J.S. THOMPSON
ENGINEERING, INC

November 27, 2023

Per your request, the plans for the Cannell job at 6573 Old US 421 in Lillington, North Carolina were reviewed to address the construction of the carport roof framing.

Cannell Residence

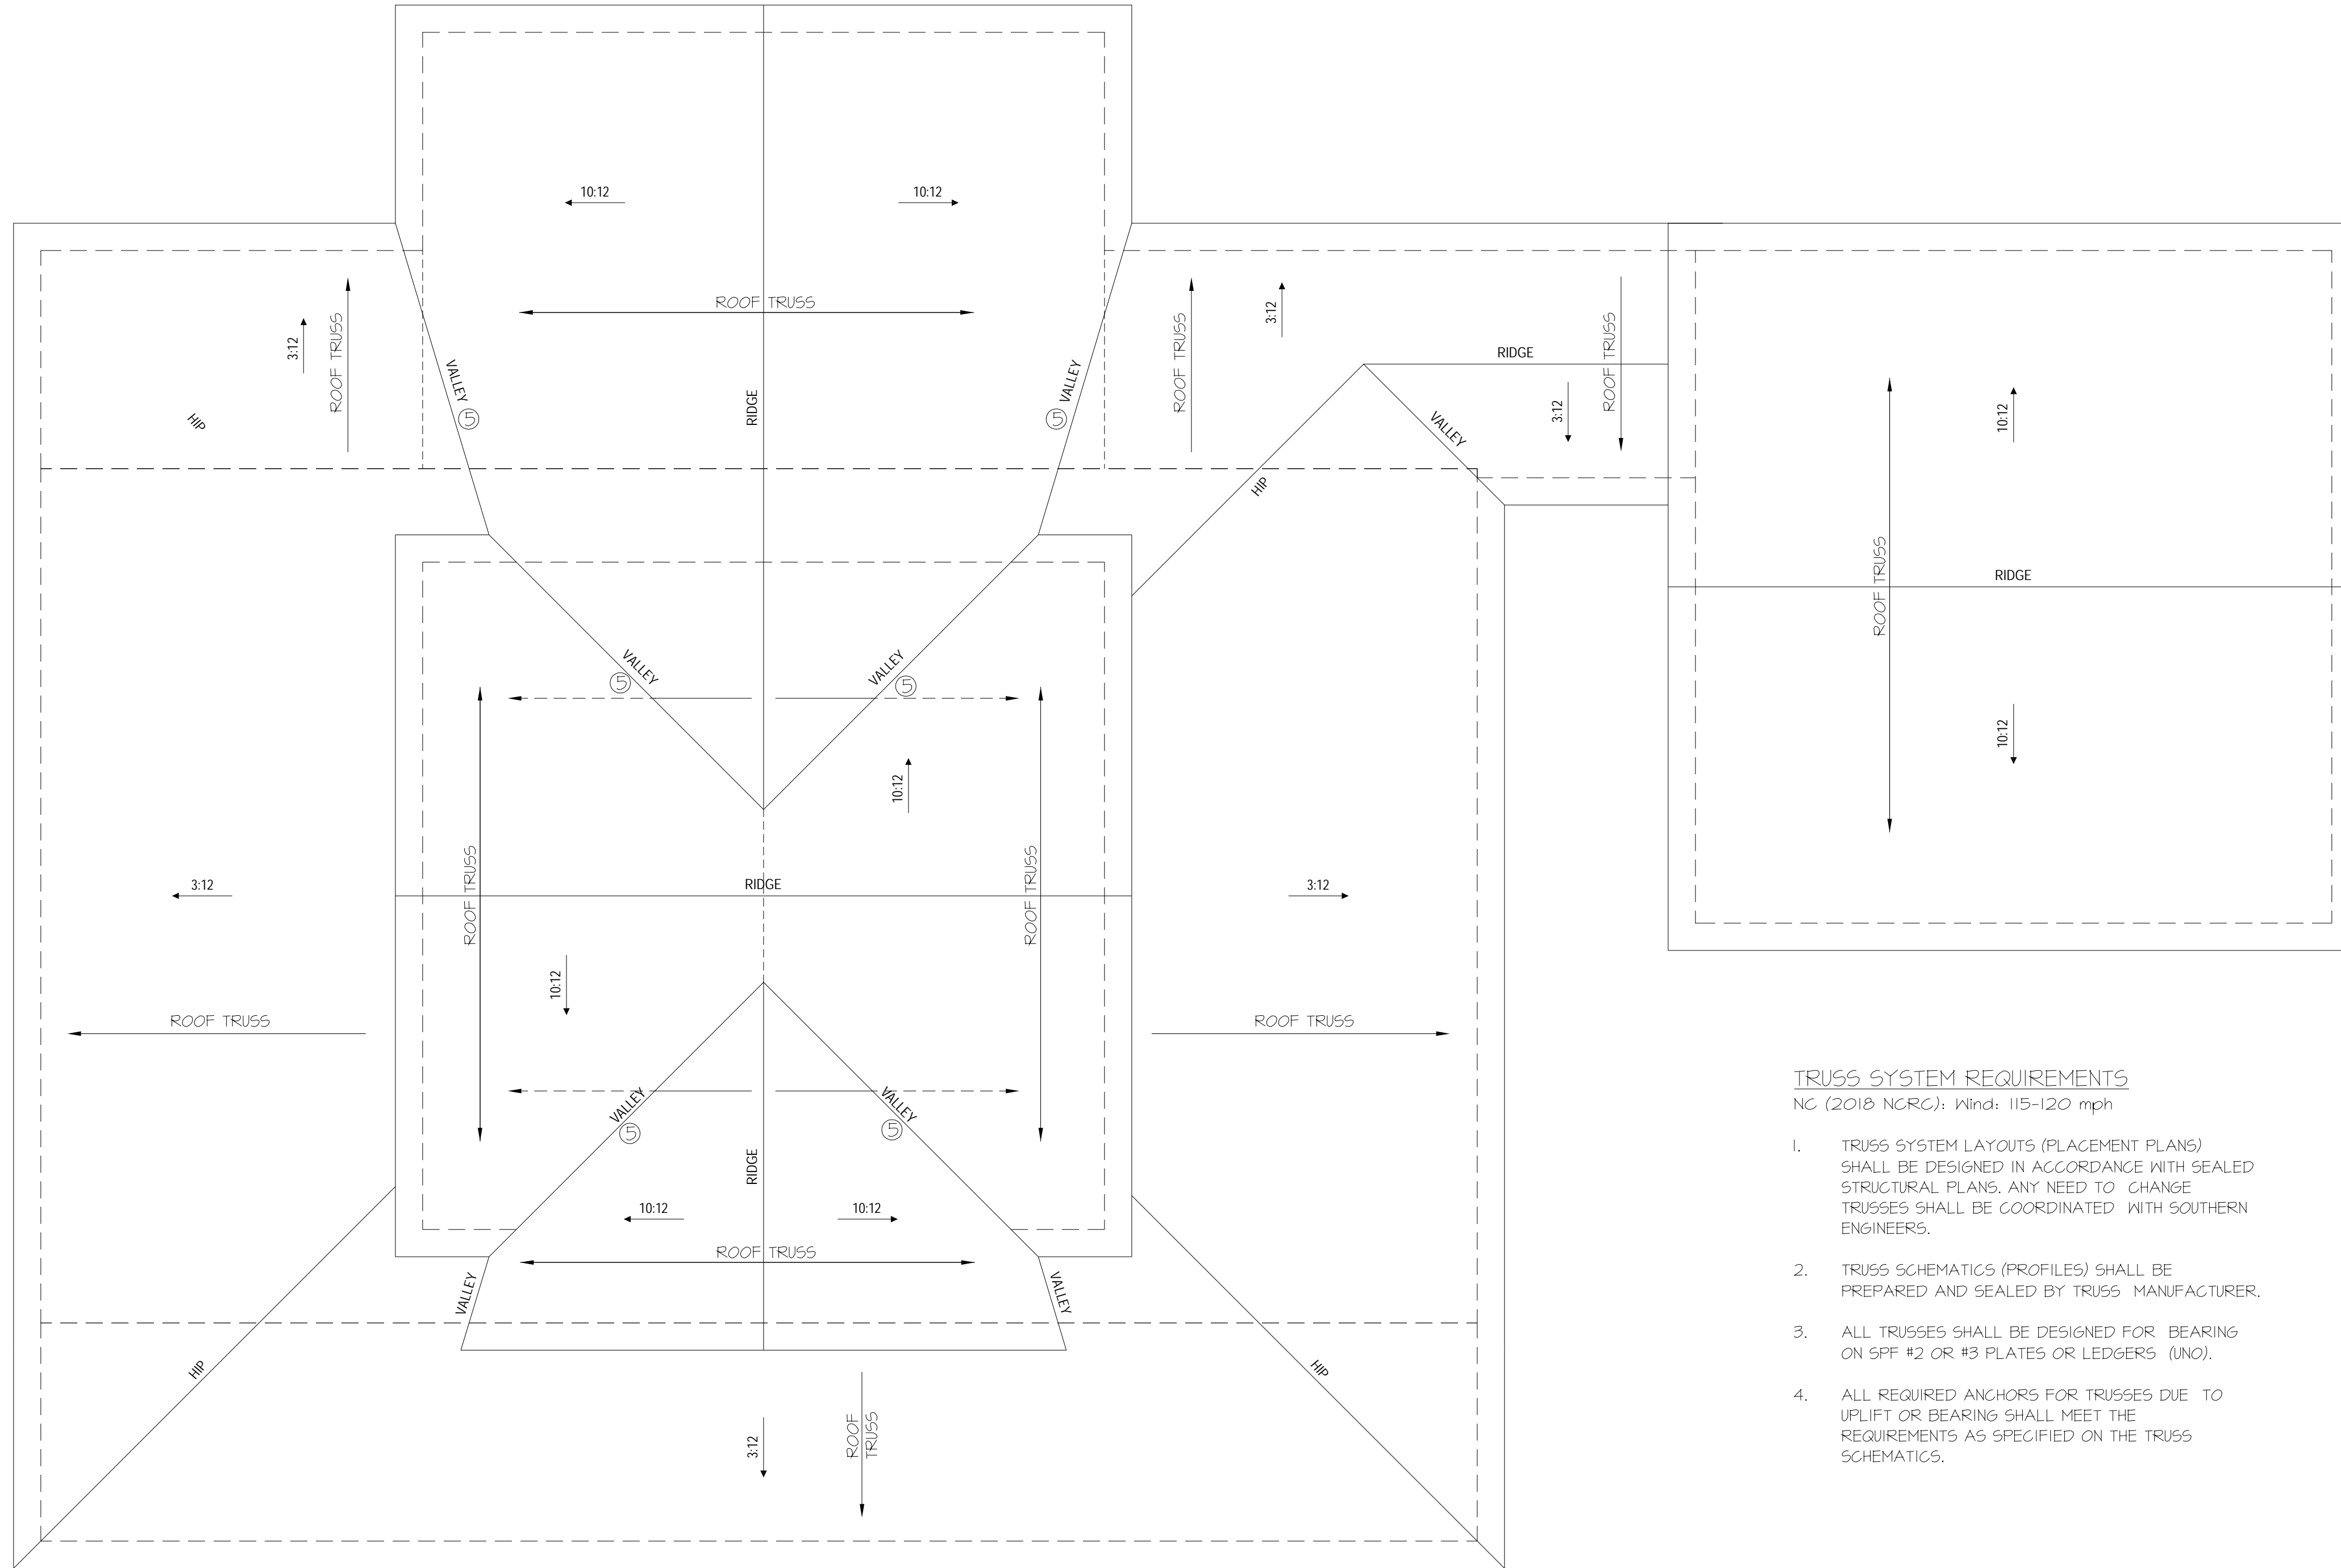
Review of the plans and the pictures you provided of the roof framing using a 2 x 10 ridge, 2 x 8 @ 16" on center rafters with fully lapped collar ties fastened with a minimum of (10) 12d nails per end and analysis of the structure revealed the "as-built" roof framing to provide the required support for all vertical and lateral loading as required by the 2018 NCRC. No modifications are required.
